**COMMENT RESOLUTION FORM**

<b>Date:</b>	6/1/2022	<b>Disposition Codes:</b>	
<b>FHU Project Number</b>	117253-08 EPC Reviews 2022	<b>A. Accept Comment</b>	<b>E. Comment Conflicts with Previous Direction</b>
<b>Project Name:</b>	Sterling Ranch Road over Sand Creek Bridge	<b>B. Delete Comment</b>	<b>F. Designer to Evaluate Comment</b>
<b>Project Number:</b>		<b>C. Clarify Comment</b>	<b>G. Discuss Comment; Follow-up Required</b>
<b>Client:</b>	El Paso County	<b>D. Disagree with Comment</b>	
<b>Designer:</b>	Contech Engineered Solutions; KBJW		
<b>Submittal:</b>	Review 1	<b>Other Review:</b>	N/A

<b>MOONTZ BRYANT JOHNSON WILLIAMS</b> Formerly CBC Engineers	
<b>UPSTREAM HEADWALL DETAILS</b>	
Drawn By <b>DJH</b>	Date <b>4/18/22</b>
Approved By	Date
Scale <b>GRAPHIC</b>	Project No. <b>KBW-24879</b>
Rev. <b>-</b>	Sheet <b>3 OF 6</b>

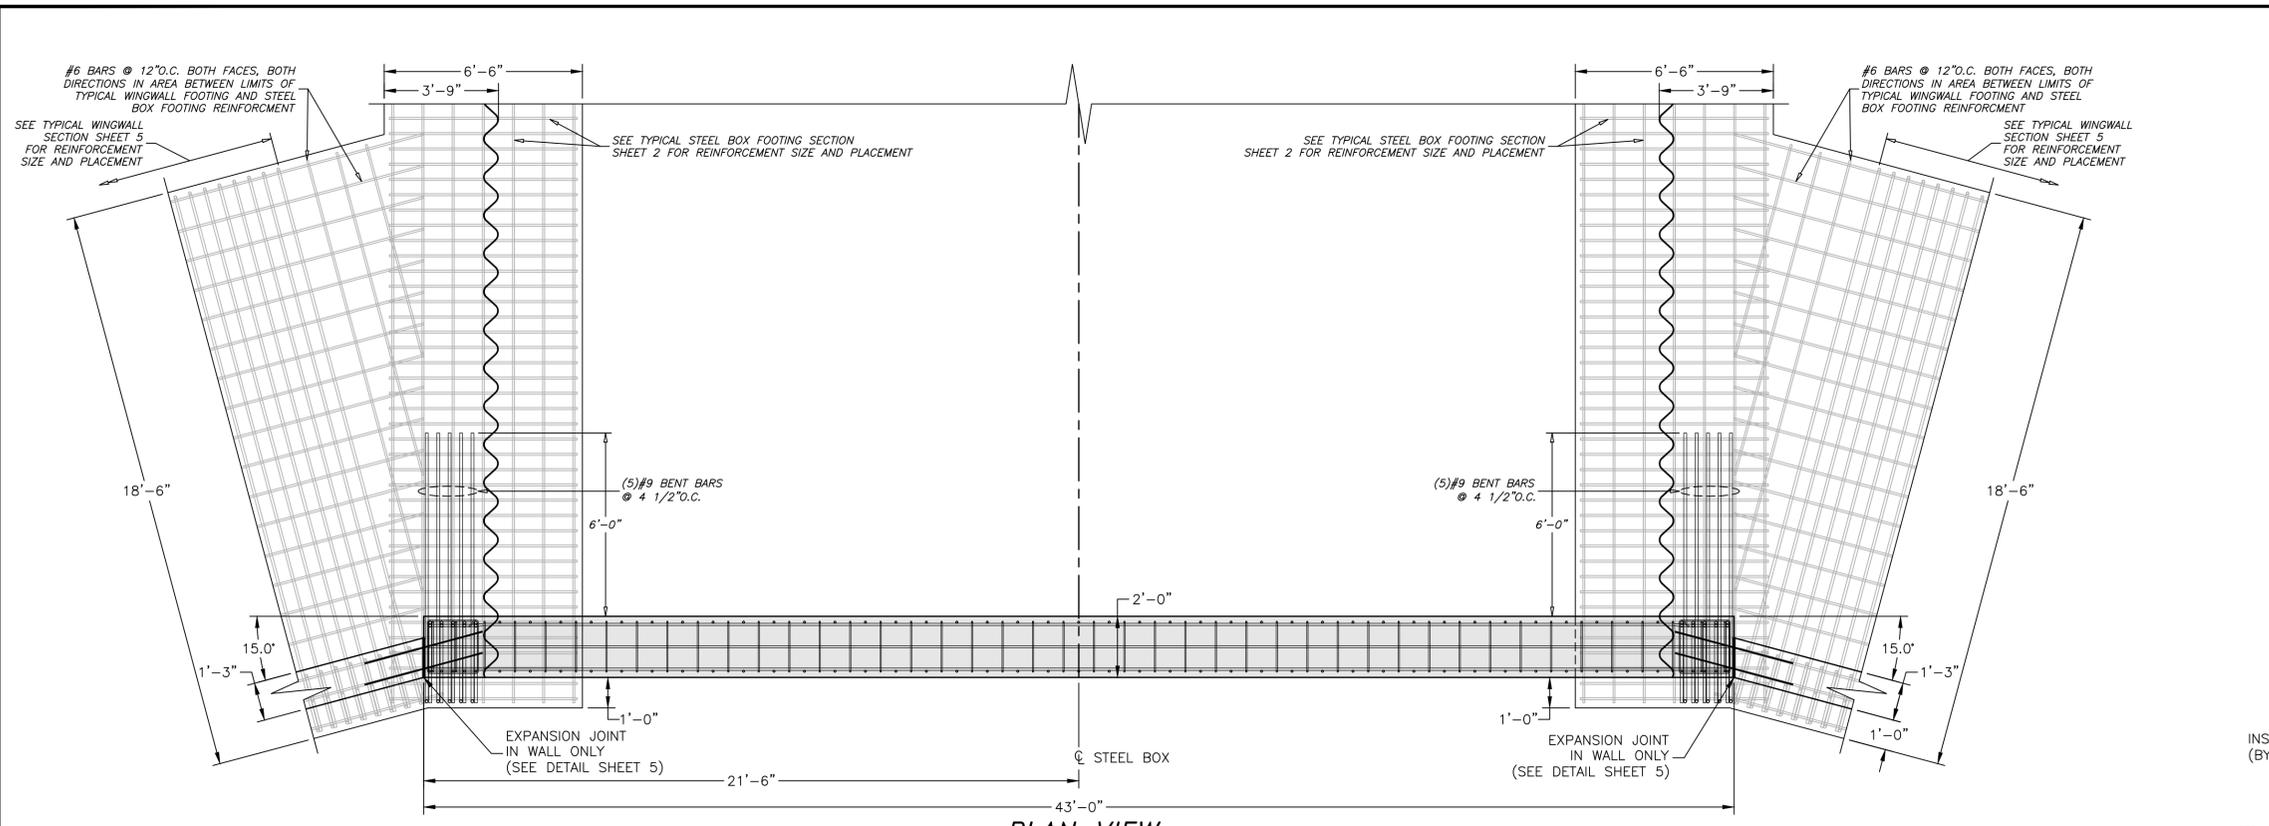
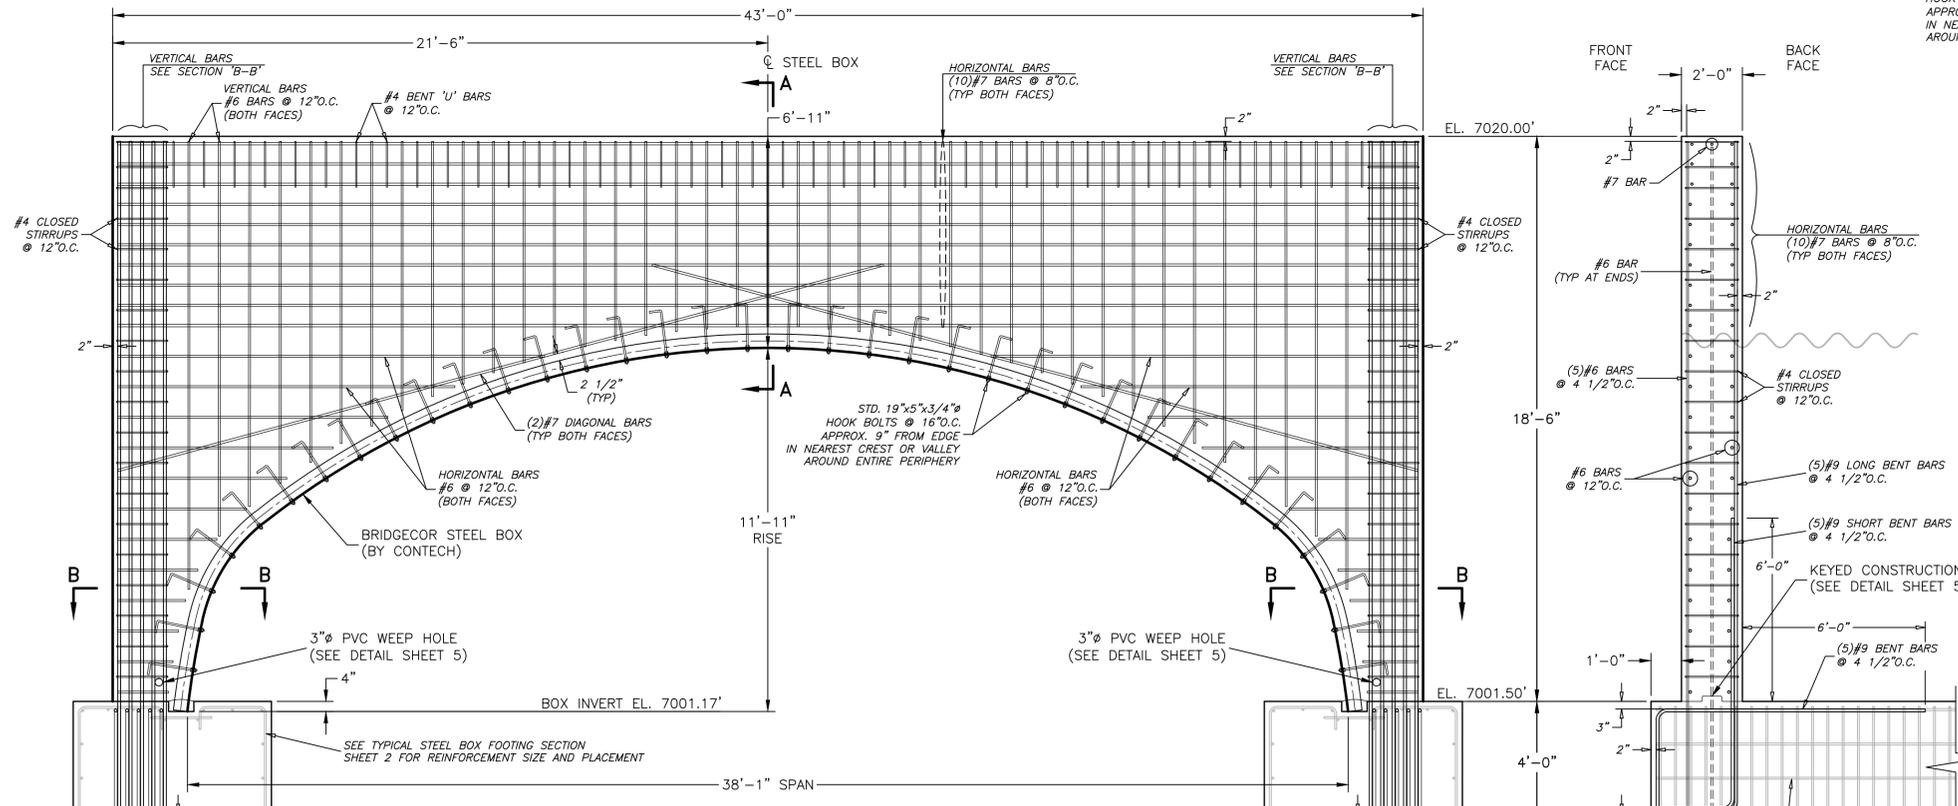
Reviewer Comments				Designer/Consultant Response			Final Disposition		
Comment No.	Reviewer	Sheet/ Page No.	Comments	Initial Code	Date	Response	Code	Date	Initials
1	CAO	CONTECH plan sheet 3 of 7	Headwall		7/15/22	Updated	A	8/15/22	CAO
2	CAO	General calculations, CONTECH plan sheet 6 of 7	Confirm fill does not exceed 5'-0" per design. It is unclear from the Grading and headwall plans what the maximum fill height will be.		7/15/22	Please see revised plans and report for better defined fill height over structure. Planned fill height min. is 5.1' and a max. of 5.75' per the revised report.	A	8/15/22	CAO
3	CAO	KBJW plan sheets 3, 4	An indication of FG height below TOW at BF would be helpful in this section.		7/15/22	Dimension now added to sections	A	8/15/22	CAO
4	CAO	KBJW Bridge Design Report pg 1	Addendum table with updated bearing capacities not provided for review. The referenced Entech Engineering report for Job No. 211647 for Briargate Parkway over Sand Creek does not indicate the bearing pressure noted here. Please provide addendum/report for verification.		7/15/22	Geotech. Addendum previously provided to Jeff Rice directly	G	8/15/22	Still require the addendum and/or report for verification of bearing pressures noted in KBJW report.
